Consultation Response
 Transport for NSW
 PO Box K659
 Haymarket NSW 1240
Projects@transport.nsw.gov.au

We the undersigned are concerned about the impact of the proposed access road though Tiggers Honeypot Garden (the Garden).

You can review the *MODIFICATION REPORT: SSI-6042 MOD 4, Stop changes – High Street, Randwick* which outlines the changes to the design and proposed access road which is proposed to dissect Tiggers Honeypot Garden in half.

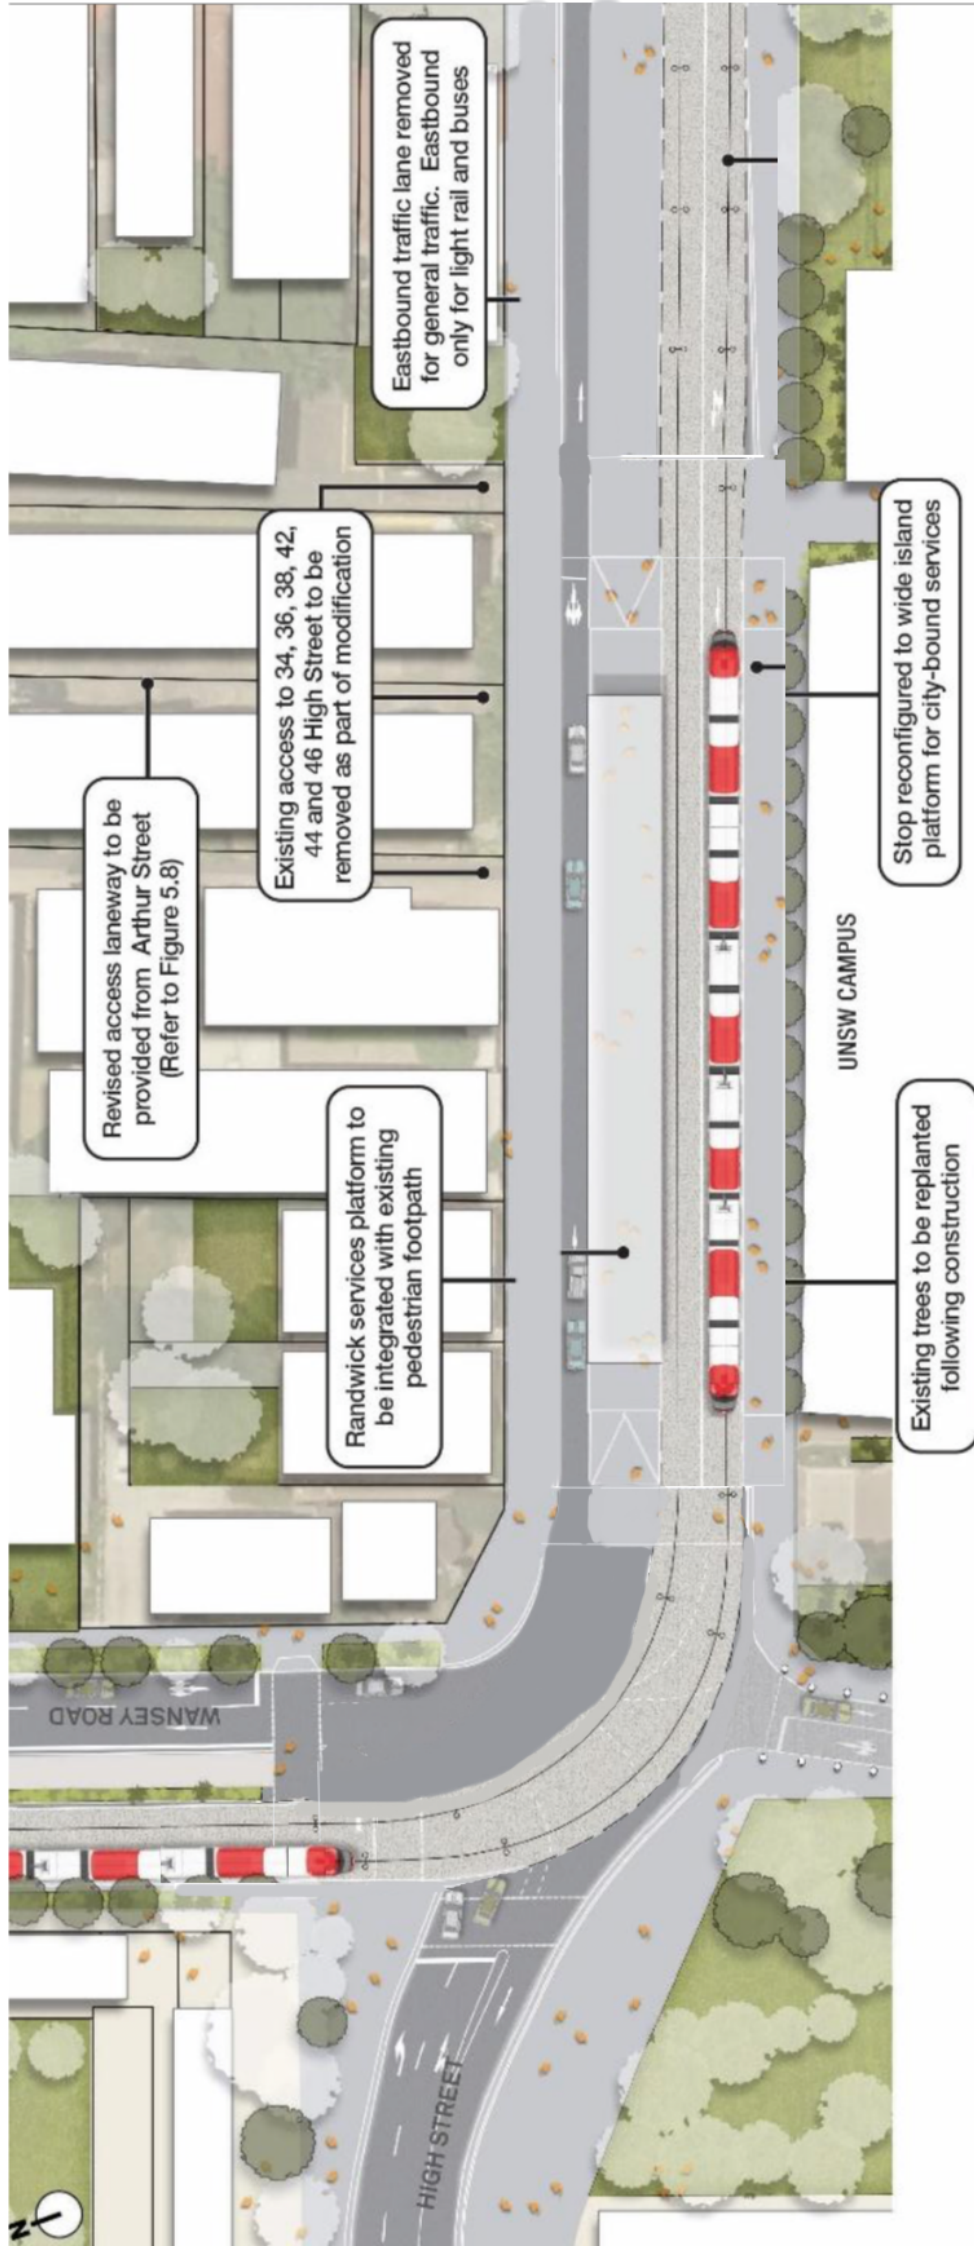
- 1.2 Proposed design dissects Tiggers Honeypot community garden in half rendering the remaining garden in Lot 1 DP330632 (western section of the garden space) inaccessible for the children due to safety concerns.

- 1.3 Uses too much of Lot 1 DP 60283 (Tiggers Honeypot community garden space and facility) and is too close to the facility (building) – particularly the babies (6 weeks to 18 months) room.

- 2.1 **None to minimal impact to Lot 1 DP 60283** (eastern section of the Garden and building) and that the land to be maintained for use by Tiggers Honeypot as a garden space.
- 2.2 **Minimal impact to Lot 1 DP330632** (western section of the Garden)
 - 2.2.1 The proposed access road on Lot 1 DP330632 does not connect to Lot 100 DP836801 (36-38 High Street - Kenvale College) but via Lot 1 DP546495

- 2.2.3 The proposed access road on this property, currently identified to be designed to a local road standard, be downgraded to a driveway.
 - 2.2.4 The proposed road moves as far as possible to the western section of the property leaving as much of Lot 1 DP330632 connected to Lot 1 60283 – to maintain the usability of the space for the community of Tiggers Honeypot.
